**Consultation Response from KC,
Conservation & Design**

2025/92140 The Old Dewsbury Library, Wellington Road, Dewsbury, WF13 1HN

Listed Building Consent for alterations to former library to form 14 apartments with associated internal and external works (within a Conservation Area)

Date Responded:25-3-26

GROUND FLOOR PLAN
1:100

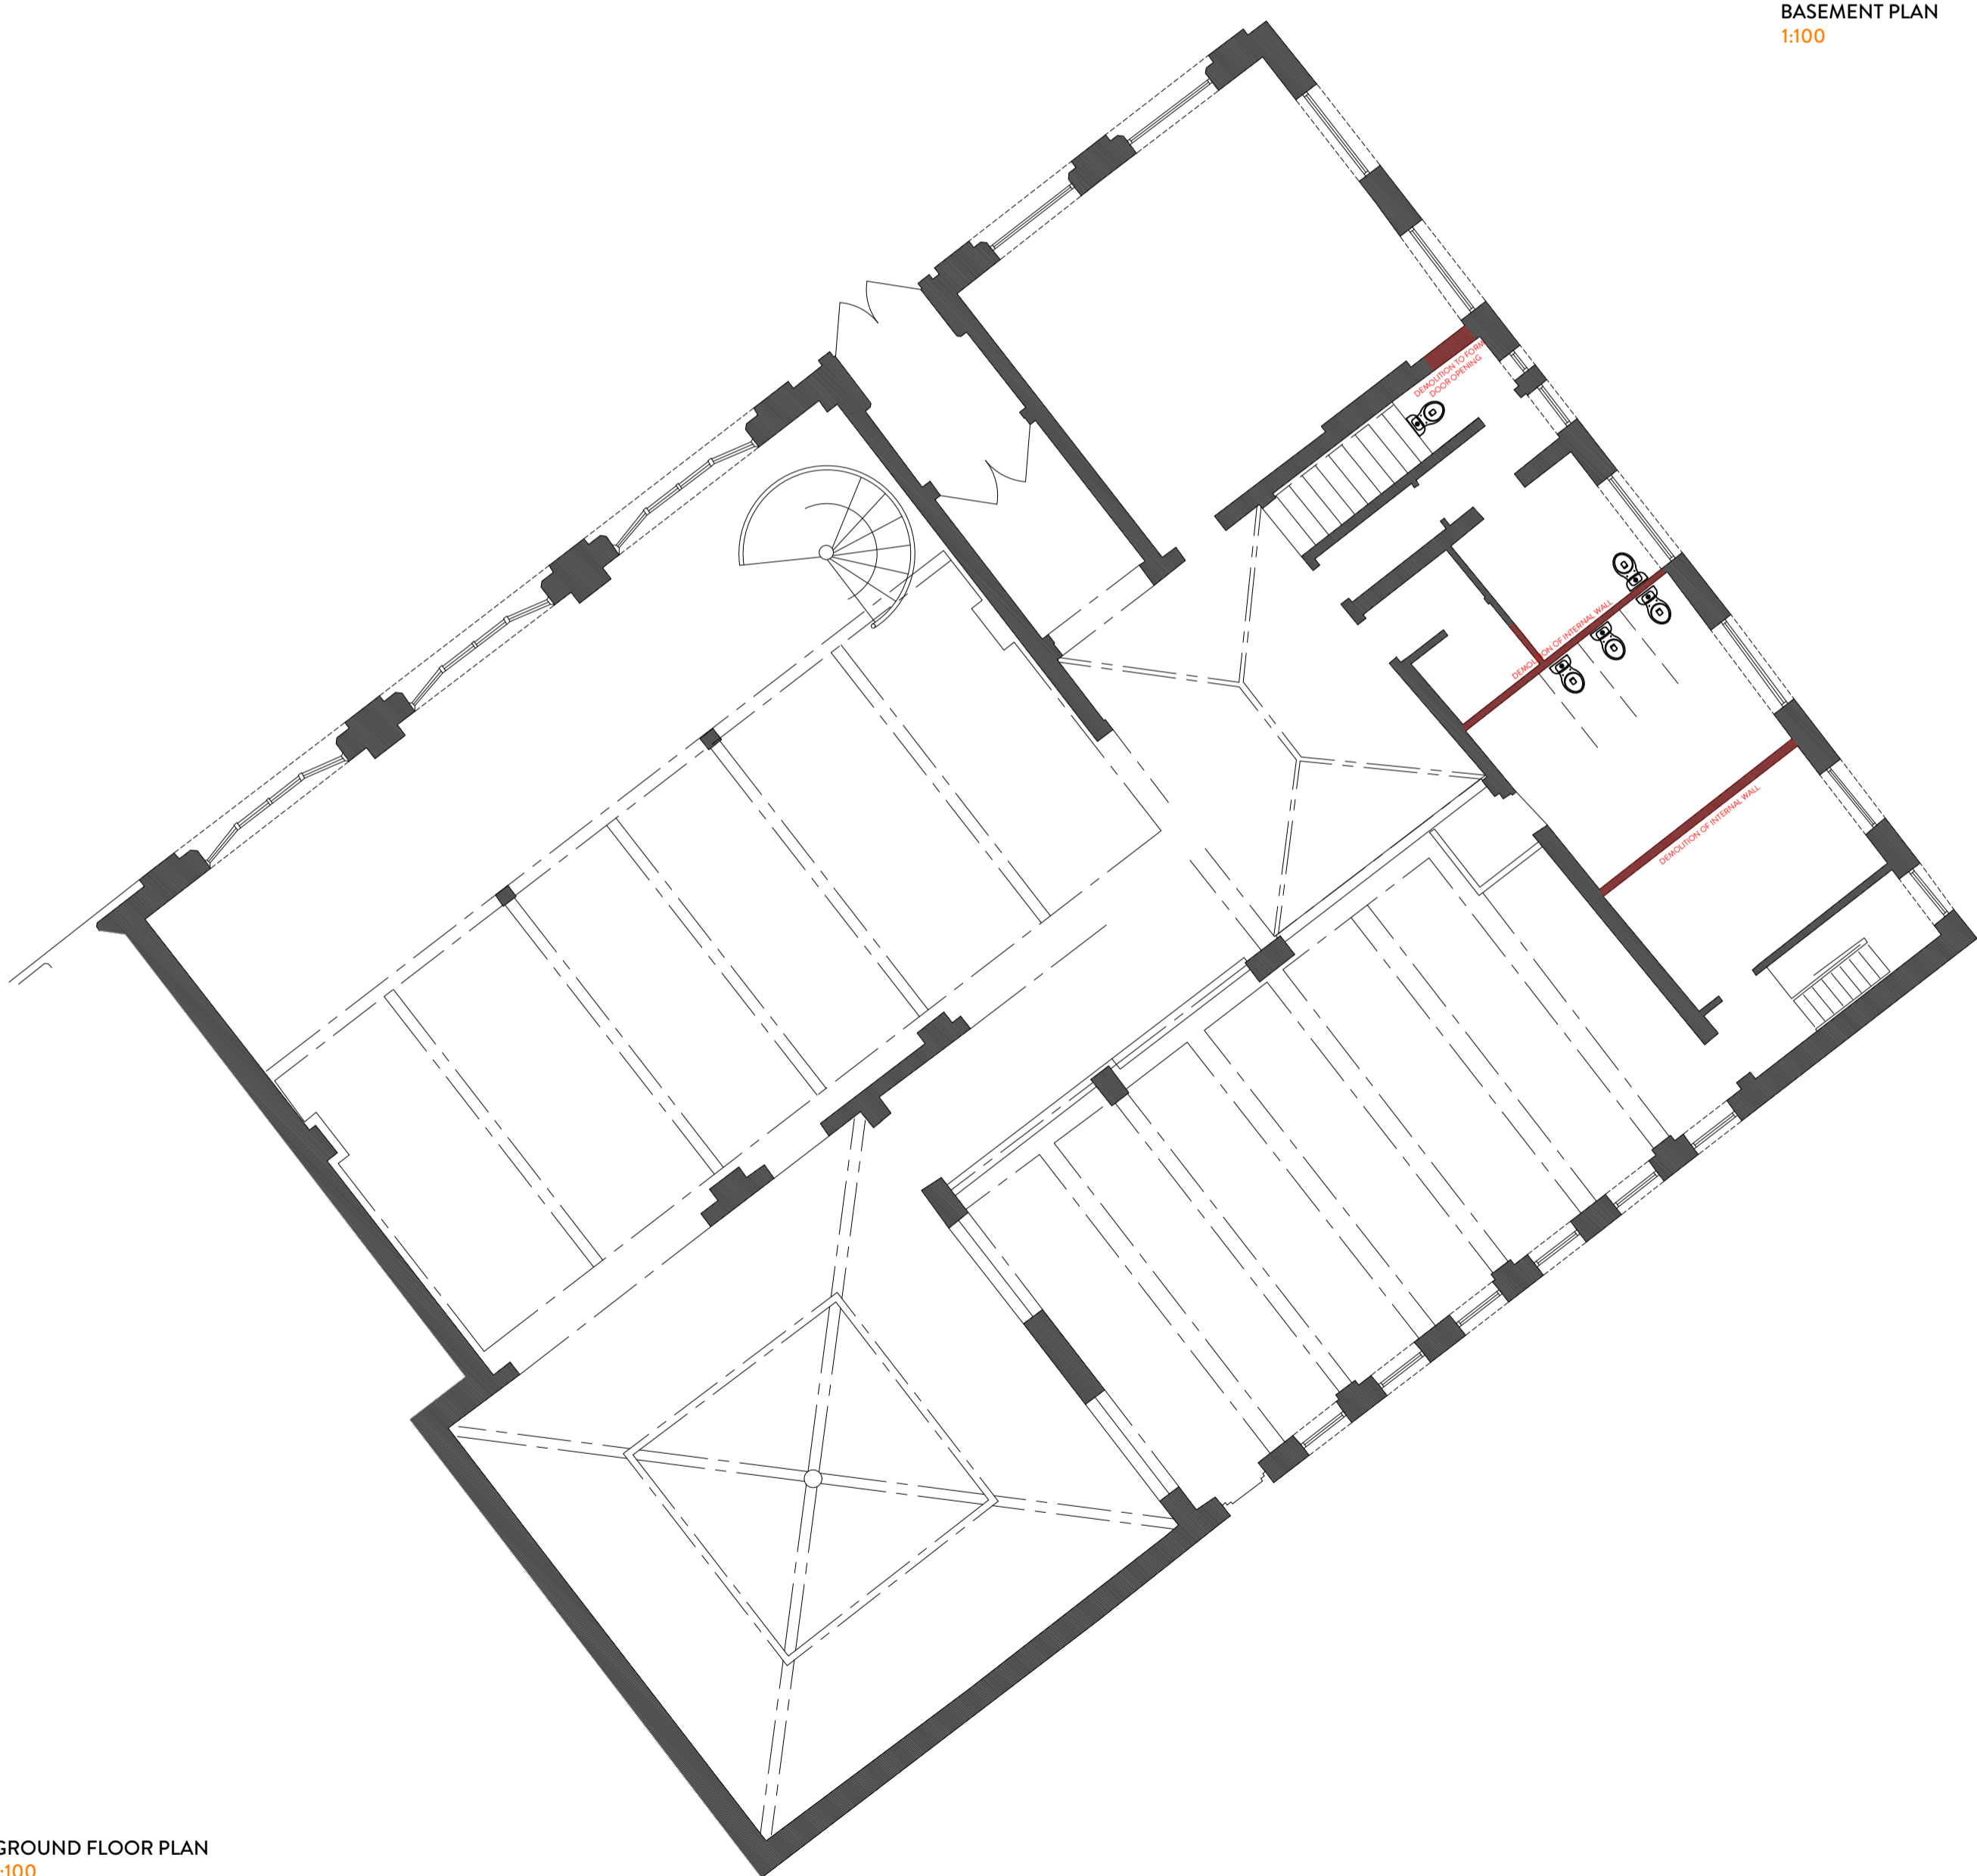
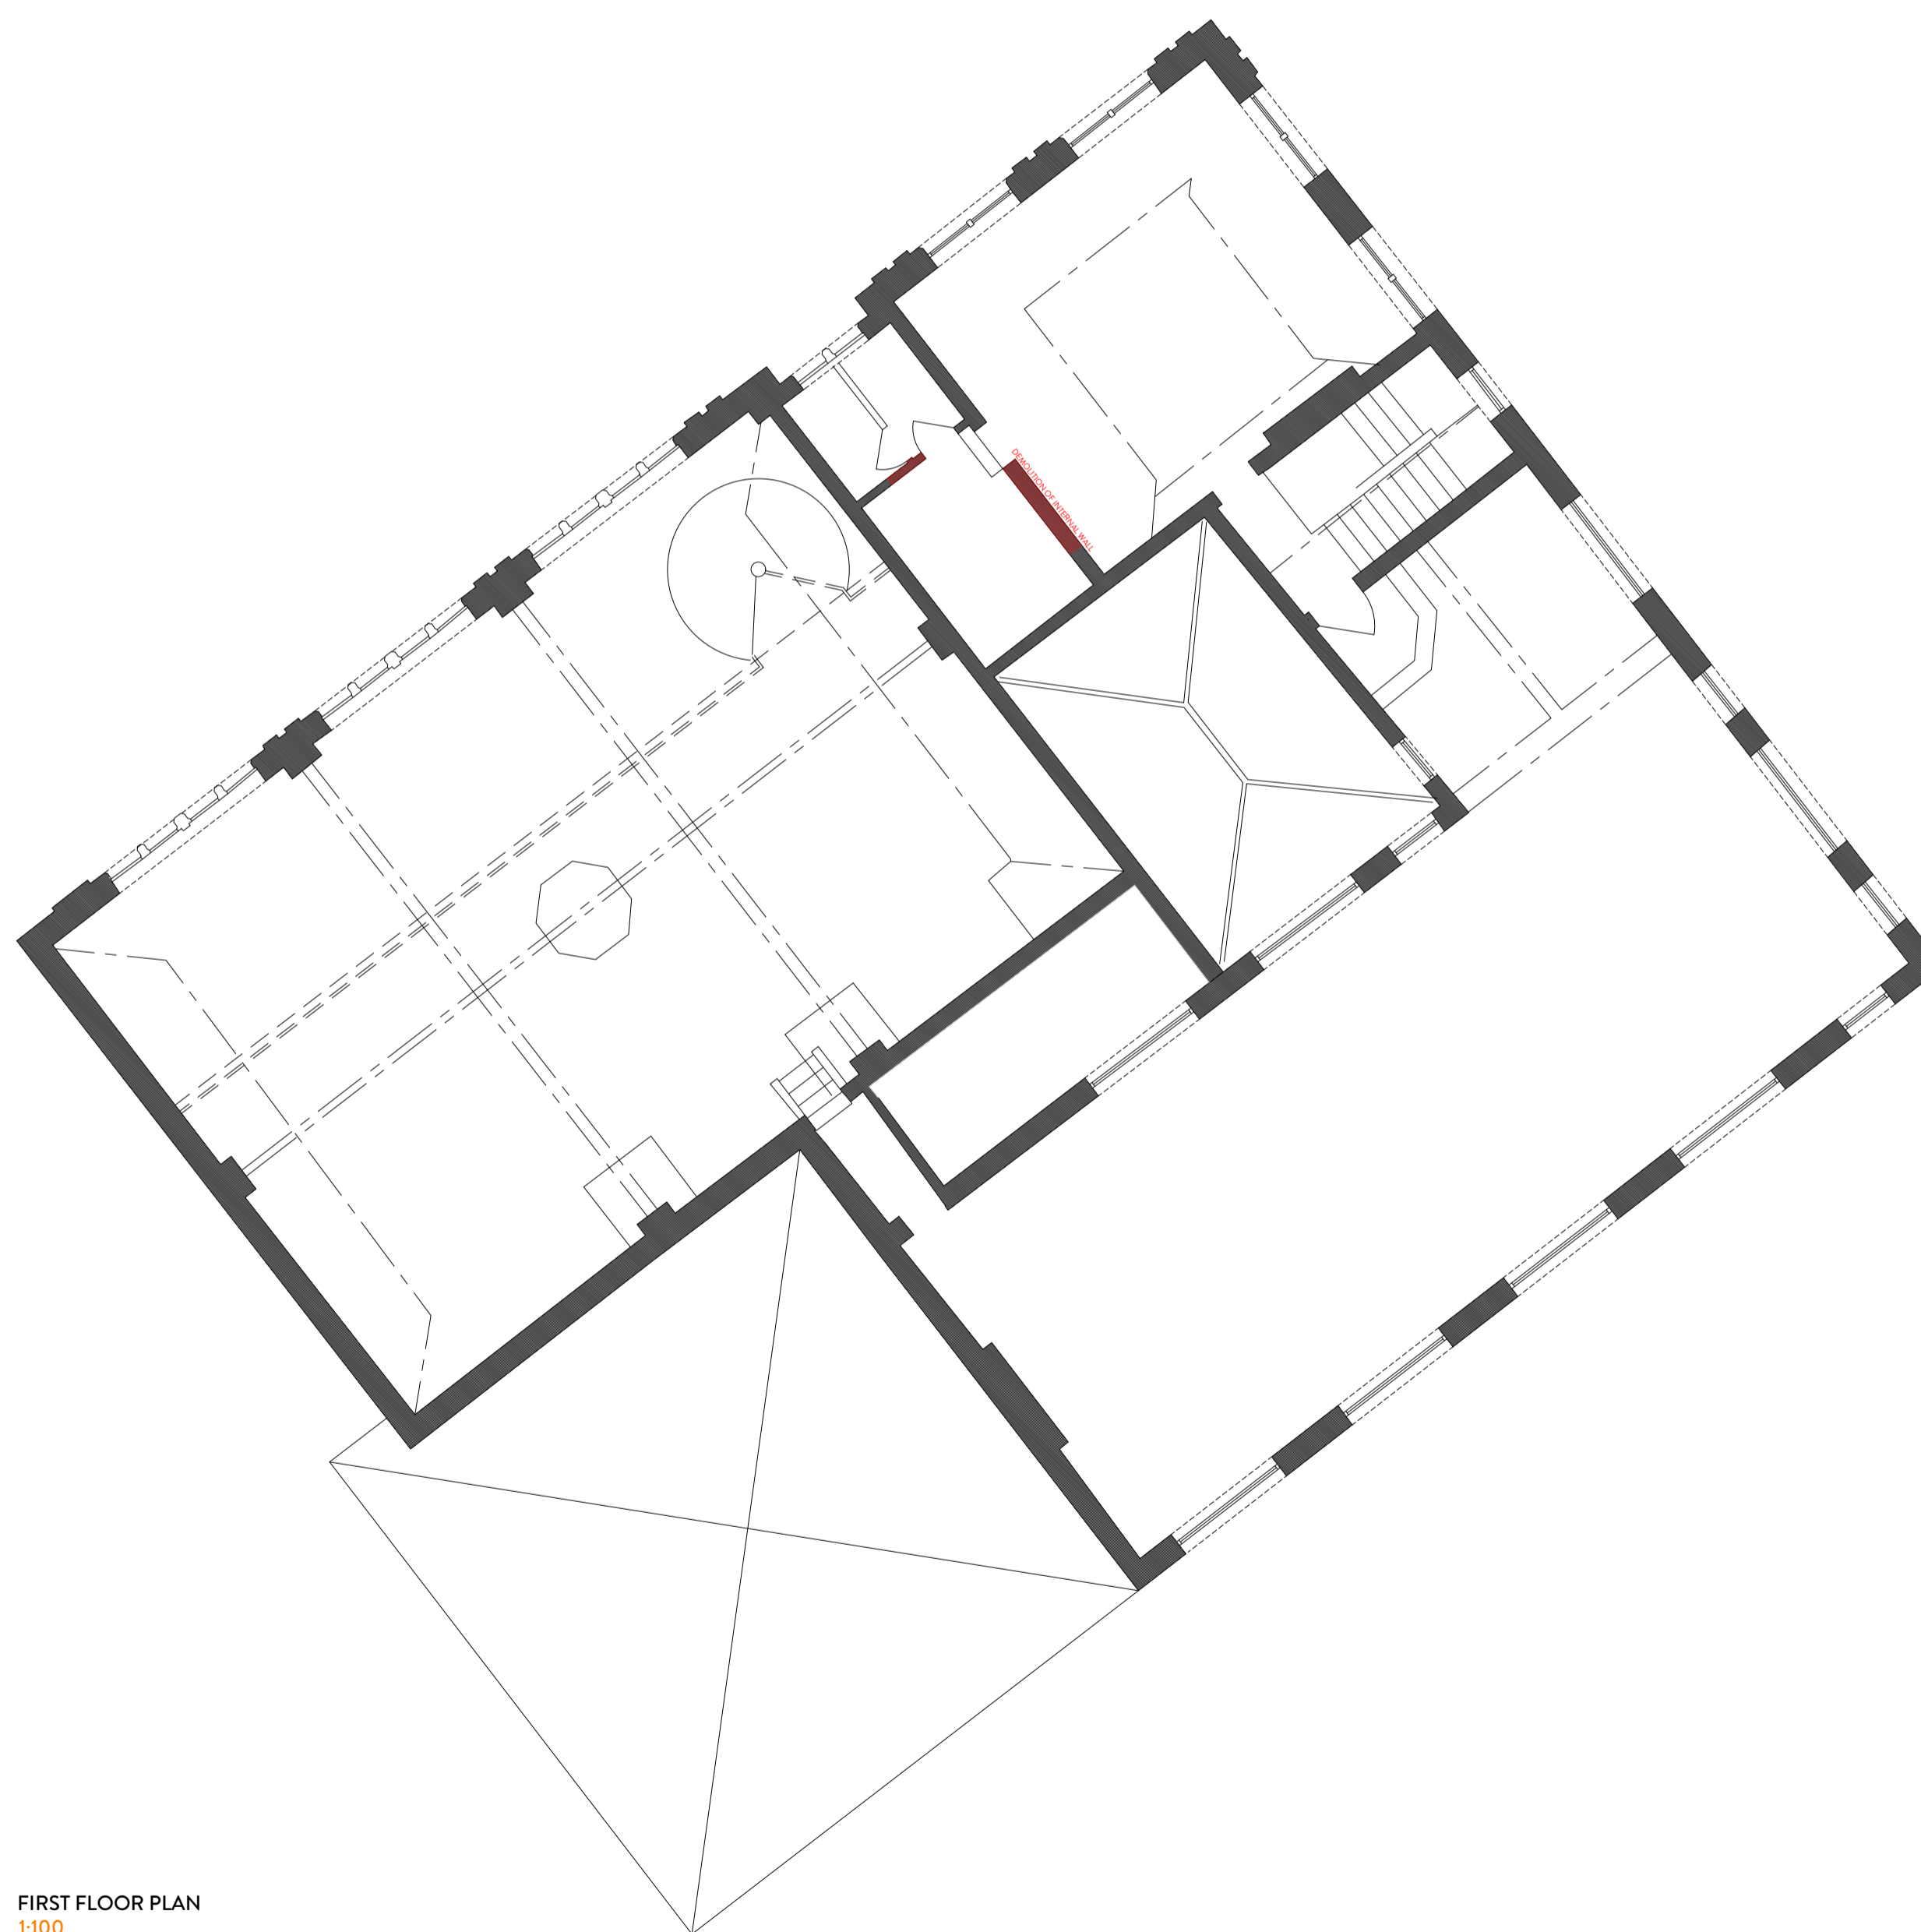
The submitted proposed elevations appear to retain the existing openings, but clarification is needed for the location of new openings referred to in the Design Pack Rev C – P.18 – 1 new window at first floor side elevation (southwest) and 4 new windows to ground floor rear (southeast). It is not clear if these have been shown on plans.

1. Entrance hall – it is understood that the entrance hall could be retained as a full height space. The repair of the glazed lantern would be welcomed to match existing. It is unclear if the glazed lantern would be retained and repaired and this needs clarification. The following features should be retained;
